DECISION DELEGATED TO HEAD OF PLANNING

Application No: H17-0895-23 **Applicant:** Mr H Brown
Proposal: Conversion and extension of rural building to form single dwelling
Location: The Chestnuts Reservoir Road Surfleet
Terminal Date: 12th February 2024

PROPOSED FRONT ELEVATION

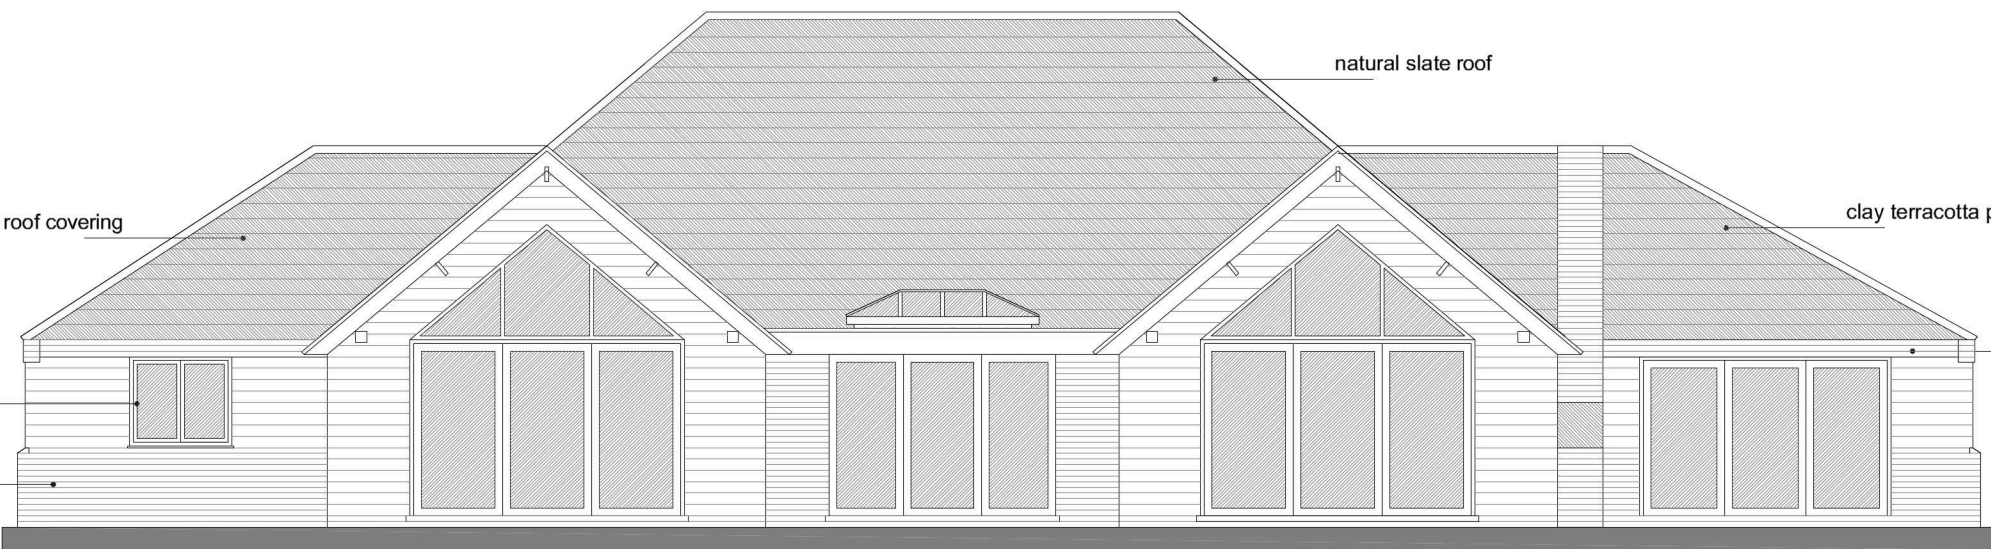
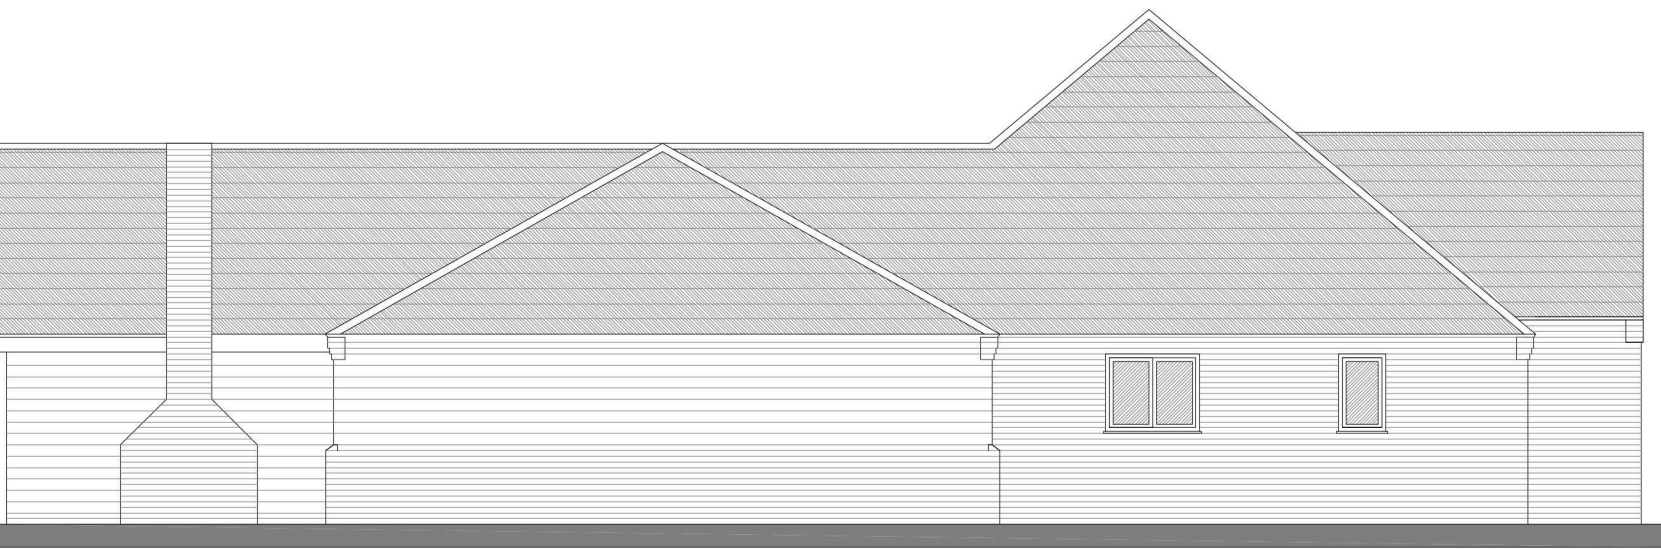
The existing site comprises an single storey agricultural building that is 3.10 metres high. The proposed development is a 6.8 metre high single storey dwelling and is relatively modern in design with a contemporary material palette of TBS Old Cottage Blend facing brick, natural cedar cladding and a clay terracotta pantile roof. The proposed building is not considered to reflect the agricultural and rural characteristics of the site.

The proposal due to its siting away from other residential properties, its increased scale and modern appearance would represent an incongruous feature that would fail to recognise the intrinsic beauty of this part of the open countries. Given its increase in scale and the open landscape which surrounds the application site there would be wider character impacts, which would have an urbanising impact across the landscape. The proposal then is considered to give rise to unacceptable character and landscape impacts.

Drawing: Planning (Block plan)

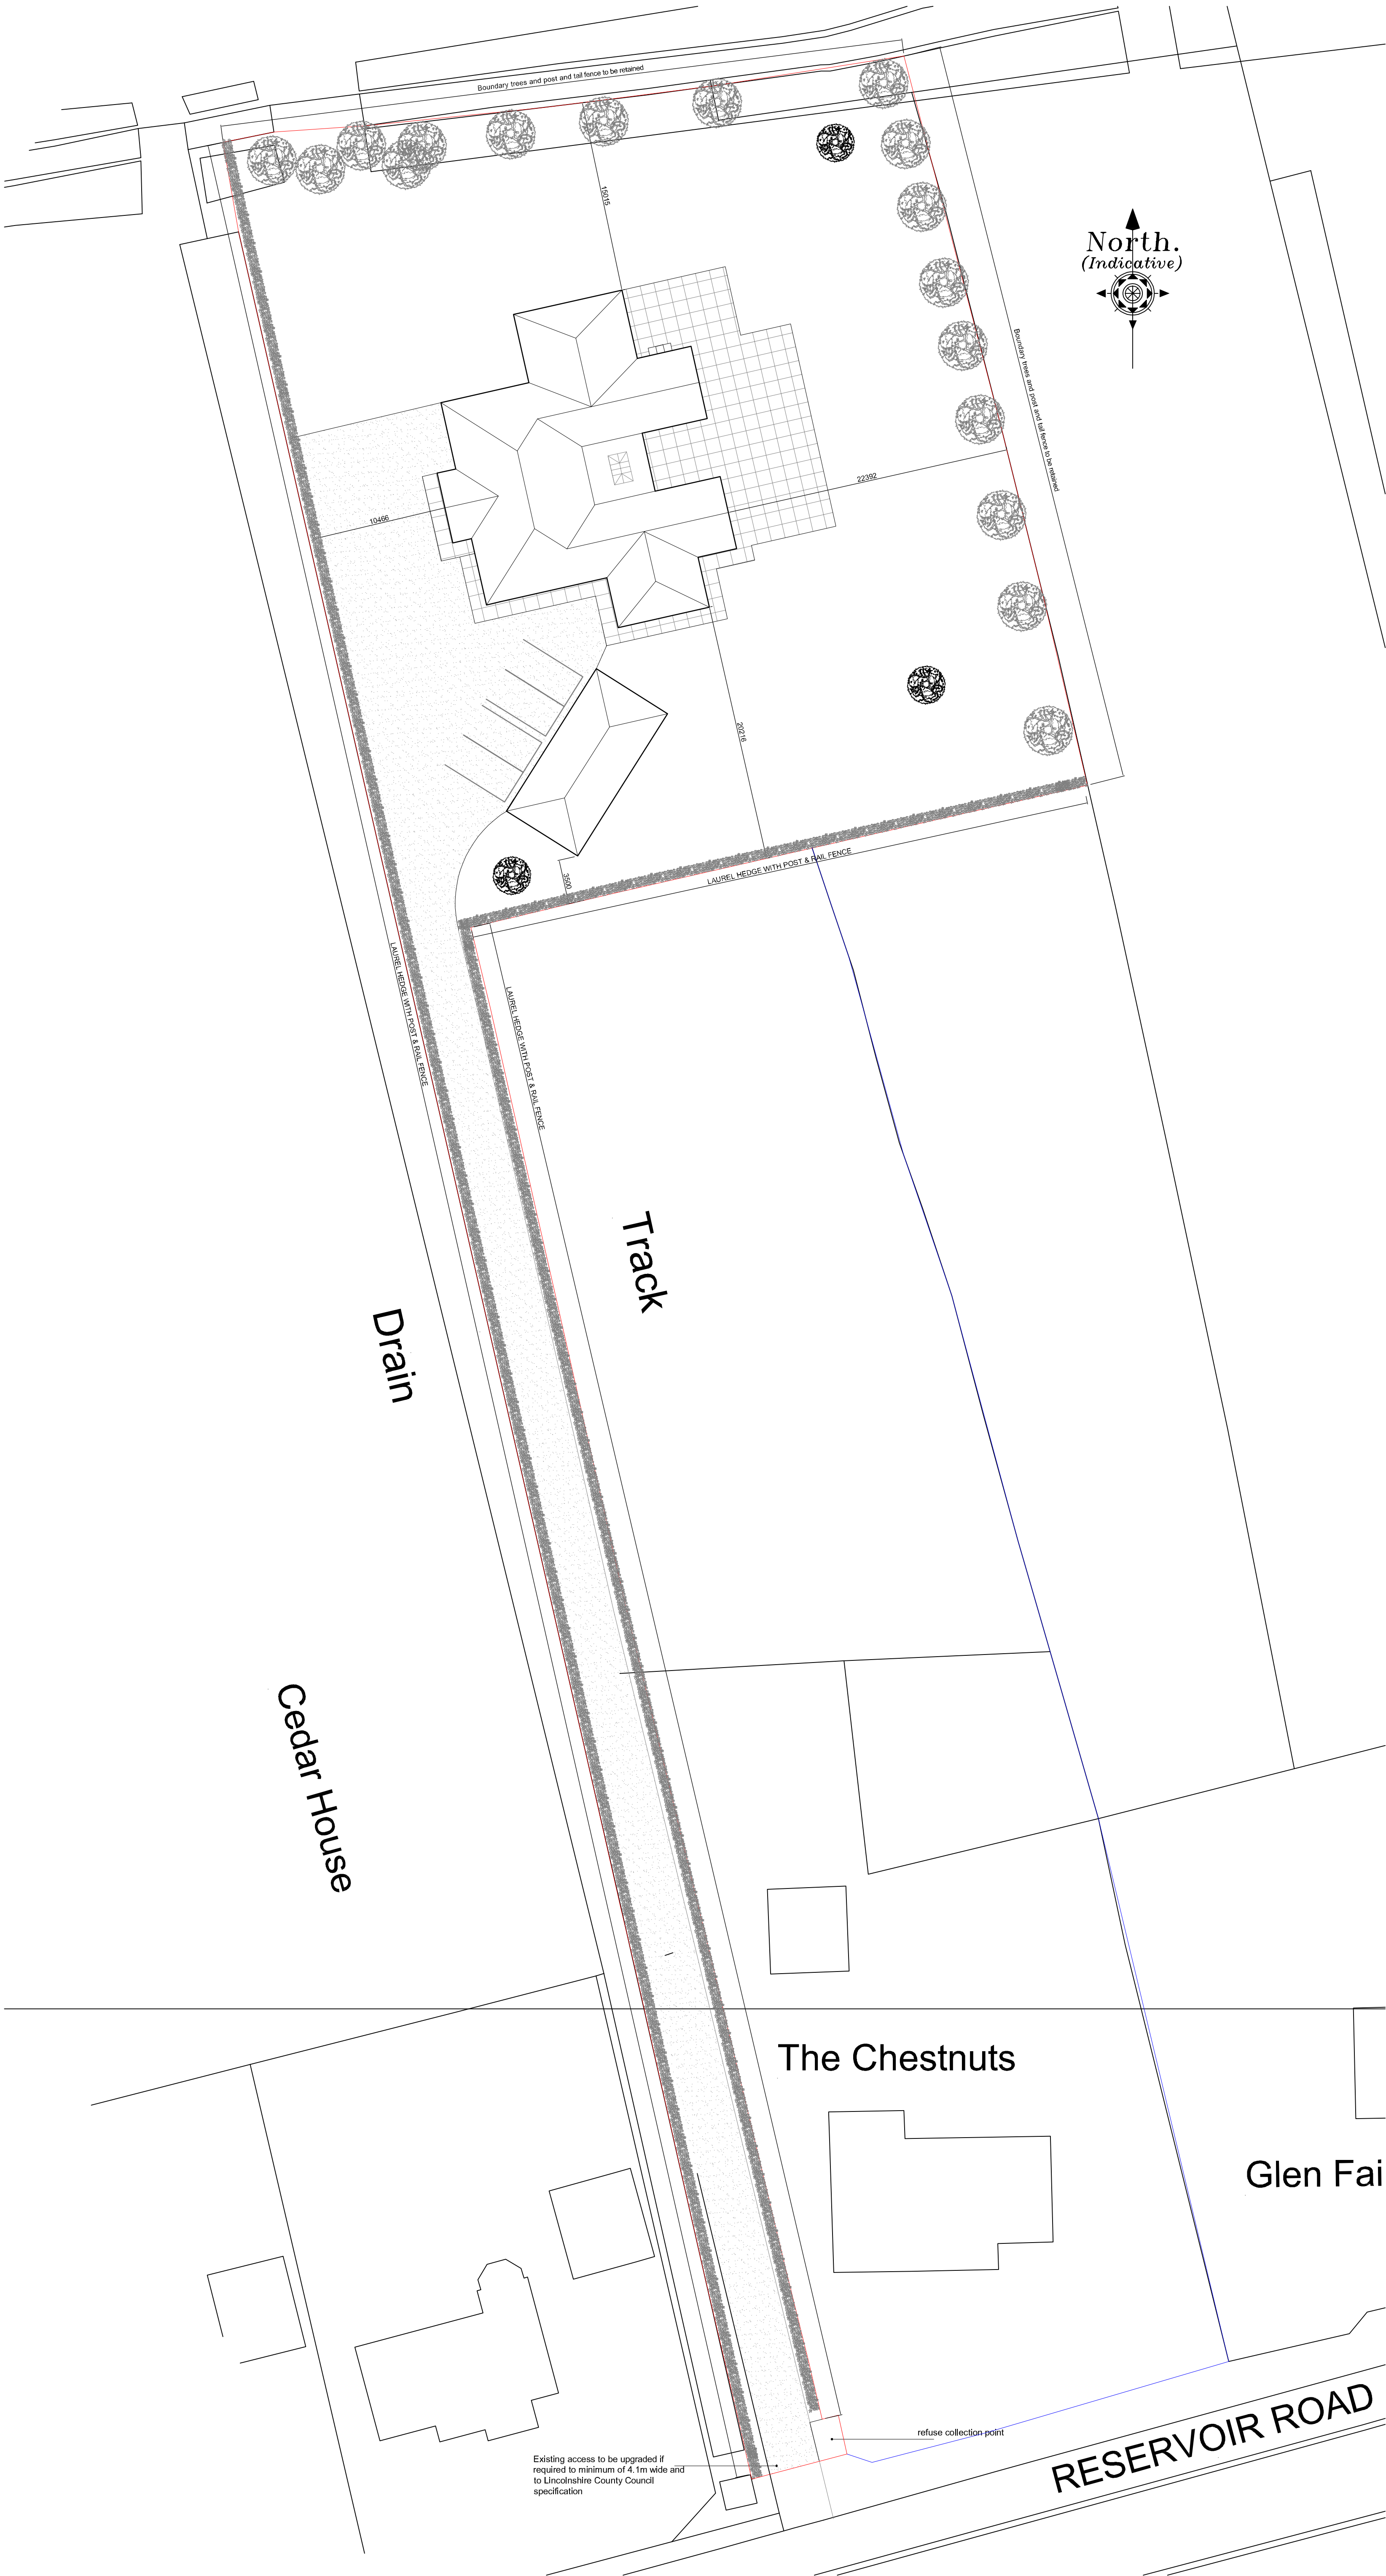
Additional Information Required - *"A shared access should measure a minimum of 4.1m wide and the access is to be upgraded to Lincolnshire County Council specification - a note should be added to the drawing detailing this information."*
